Office of
Environment
& Heritage

Our Ref: DOC19/104080

**Re: Response to Submissions SSD 5792 Cairncross Waste Management Facility Expansion,
Port Macquarie-Hastings Council**

The OEH has reviewed the *Cairncross Waste Management Facility Expansion – Response to Submissions* (RtS) prepared by Arcadis dated 11 December 2018 and provides the following comments.

Figure 1-3: Proposed landfill layout and stages (Stage 2)

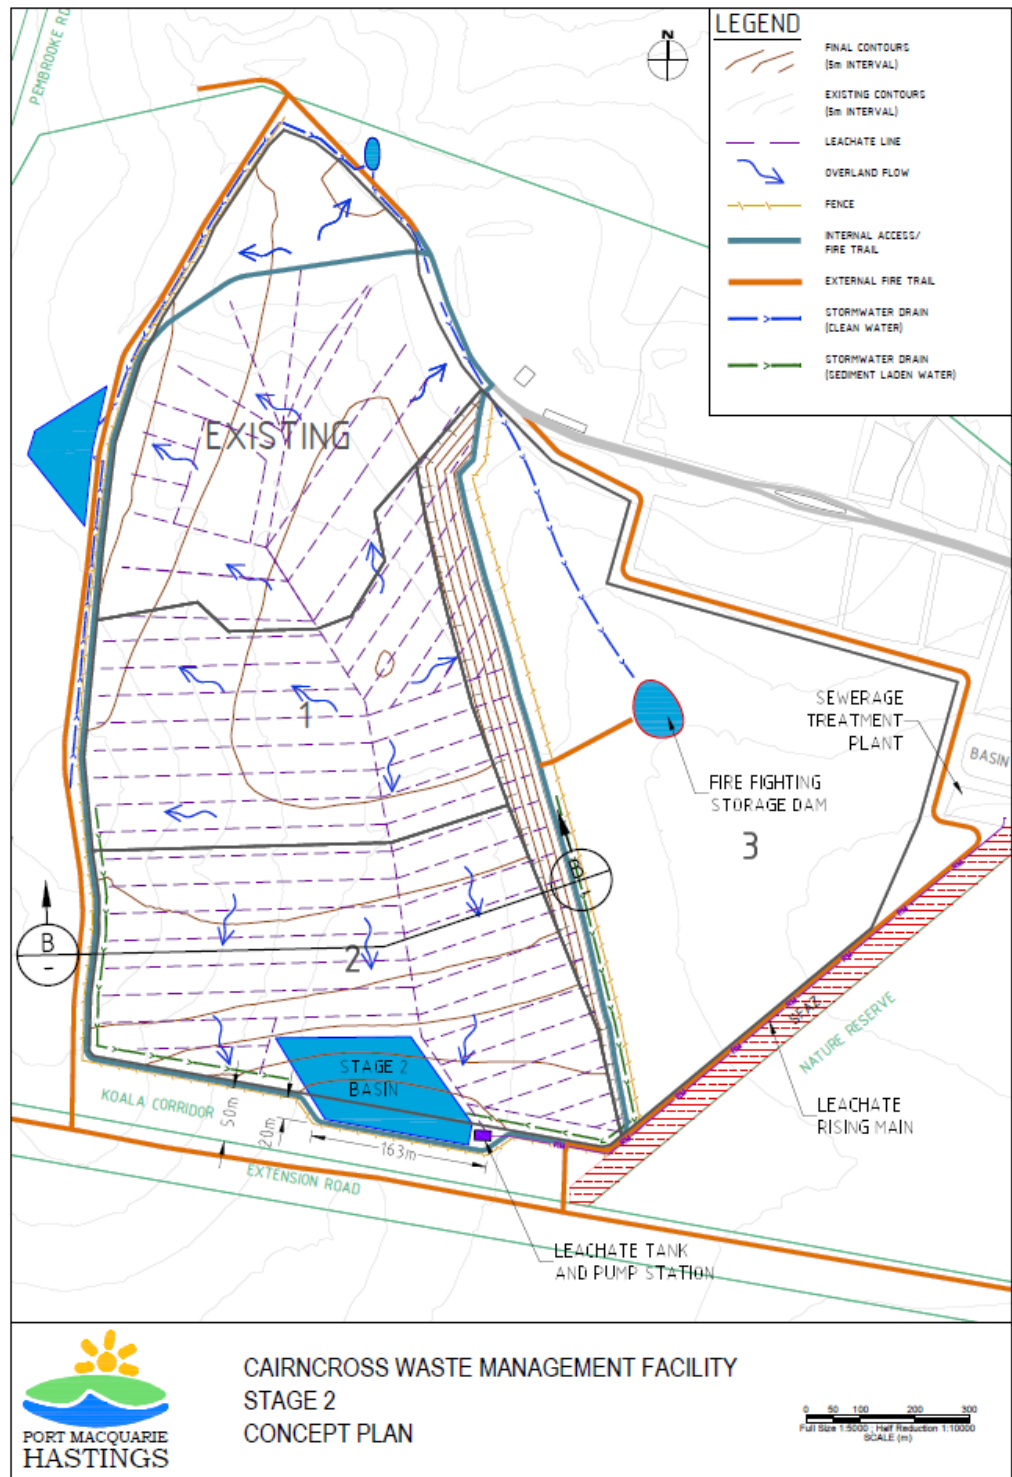
The OEH also recommended the sediment basin, leachate tank and pump station (approximately 163 m by 20 m in size) be located outside the 50 m wide koala corridor in the Stage 2 and Stage 3 development. This has not been implemented.

The RtS in addressing the Rural Fire Services response states that the koala corridor and the SFAZ will be implemented from the commencement of the Amended Proposal providing a permanent 50 m fire break to the south and 30 m fire break to the south-east. The leachate tanks require 20 m of defensible space around them and this does not seem to have been accounted for in the proposed layouts in the revised concept plan diagrams.

While we note the basin will be reduced in size over time and will be removed following rehabilitation there is inadequate justification that the remaining 20 m will provide enough area for fauna movement. The OEH does not consider the basin and the associated infrastructure to be compatible with the objective to provide an adequate corridor for koala and other fauna movement and it will prevent the effective revegetation and restoration of this area.

1. A fully vegetated buffer with a minimum width of 10 m is required to the Rawdon Creek Nature Reserve boundary and should be located outside the 30 m wide Strategic Fire Advantage Zone.
2. The sediment basin, leachate tank and pump station for Stage 2 must be relocated outside the 50 m wide koala corridor.
3. Before the application is determined, clarification is required regarding the requirement for a permanent 50 m wide fire break to the south as outlined in the RtS, as this would negate the commitment for the retention of a 50 m wide koala corridor and prevent the revegetation and restoration of this area.

**Figure 1-14: Stage 2 & 3 Boundary Typical Cross Section**

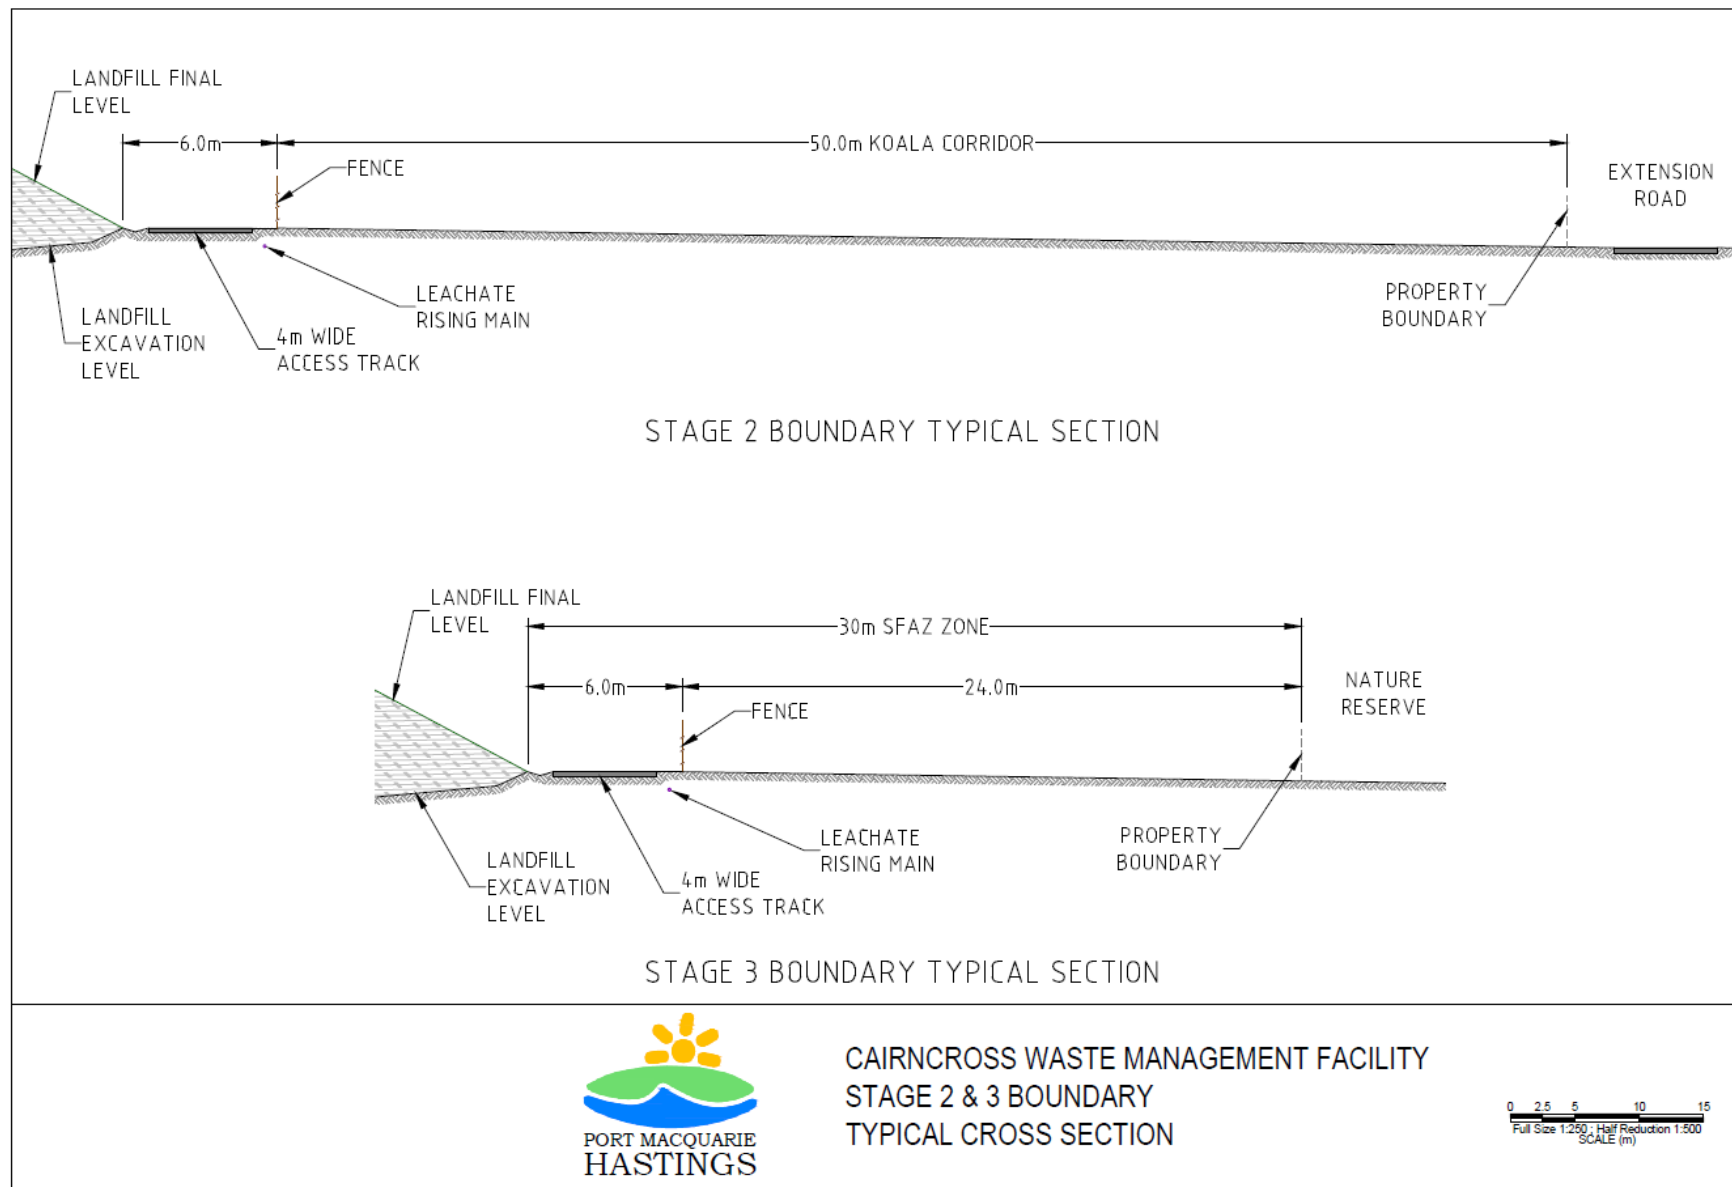
The OEH previously recommended a 50 m wide vegetated buffer to the NR) and that all infrastructure, including the Strategic Fire Advantage Zone (SFAZ), be located outside the buffer. This has not been implemented.

As described in Figure 6.8 of the RtS, within that recommended buffer there will be a 30m wide SFAZ consisting of 24 m of modified vegetation and a 6 m wide access track. The SFAZ is required to be managed "in accordance with the prescriptions provided by the NSW Rural Fire Service's Environmental Assessment Code 2006" (the Code). Under the Code mechanical work can occur in a SFAZ up to a maximum of 6 metres from boundary fencing but must not involve the removal of native vegetation older than 10 years.

The OEH supports the location of fencing along the access track rather than along the NR boundary. However, we do not consider that the proposed SFAZ will maintain adequate screening for recreational users and protect the visual amenity to the NR, as claimed in the RtS, because the native understorey and shrub layer will be cleared. A visual and ecological buffer to the NR is required that is fully vegetated.
